From: Simon Davis
Sent: 09 April 2019 12:39
To: Planning.Responses
Subject: FW: Planning Consultation on: BR/311/18/PL
Attachments: Chichester University Drainage Strategy_REV4_COMPLETE.PDF

From: Laura Gibbons
Sent: 02 January 2019 16:33
To: Planning.Responses 
Cc: Simon Davis 
Subject: RE: Planning Consultation on: BR/311/18/PL

Engineers Comments Regarding Surface Water Drainage

- SITE BOUNDARY
- EXISTING POTABLE WATER PIPE WITH EASEMENT
- EXISTING FOUL WATER PIPE WITH EASEMENT
- EXISTING CULVERTED WATERCOURSE

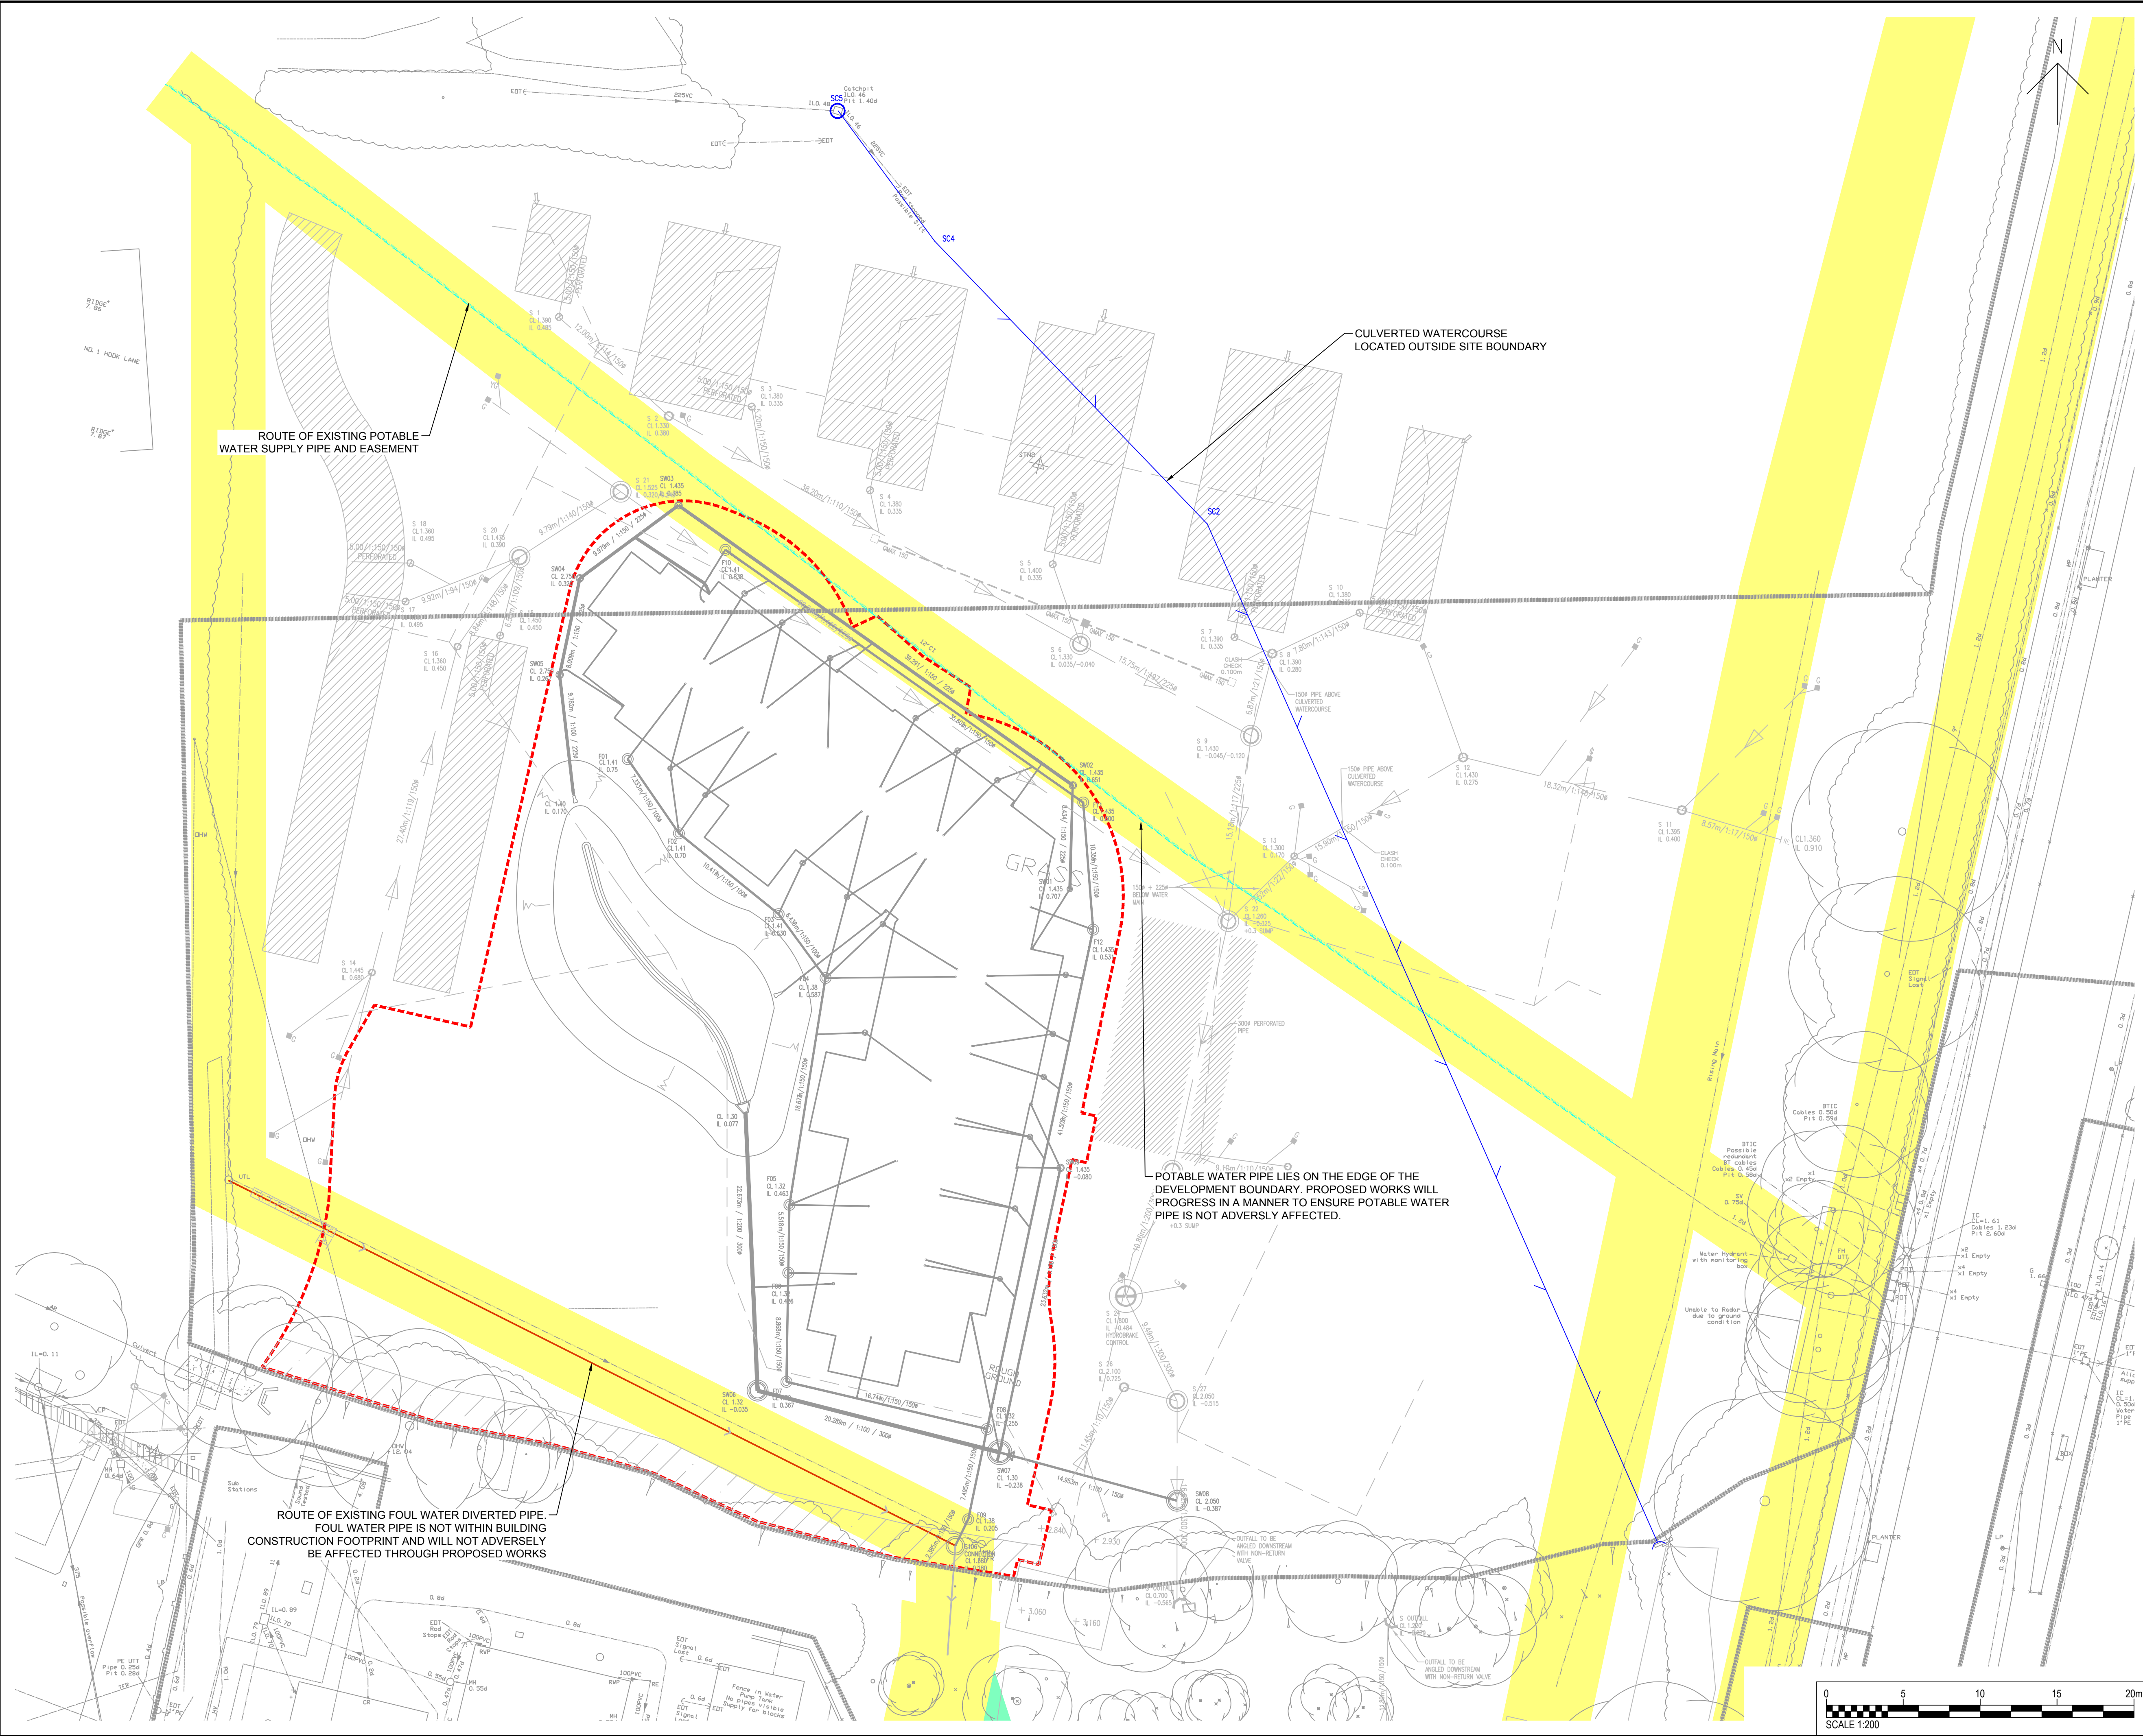
There is a private sewer running through the site which is in a poor state of repair. The applicant has been in consultation with us regarding this previously. The corrective measures identified must be undertaken. The derelict culvert that is also present in this area should be removed, the applicant is advised to contact us regarding this.
